Address: 15 Moorside Court Cleckheaton BD19 6AY

Application number: 2023/92383	
What is the application for?:	Erection of two storey and single storey rear extension with terrace above and a
Address of the site or building:	11, Moorside Court, Moorside, Cleckheaton, BD19 6AY
Postcode:	BD19 6AY

We write to object to the proposed two-storey extension at 11 Moorside Court, Cleckheaton, BD19 6AY – planning application number 2023/62/92383/E.

SOUTH ELEVATION  
1:100

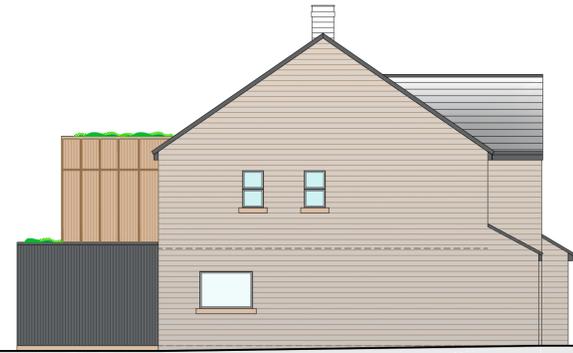
Under the proposed extension plans, a combination of the height of the extension, paired with the existing elevated aspect, would mean that the external glazed door leading onto the roof terrace would directly overlook our property and leave ourselves without privacy.

Additionally, the plans propose utilising a mixture of light and dark timber cladding, which is not in keeping with the style of the site and would look out of character against the stone properties here.
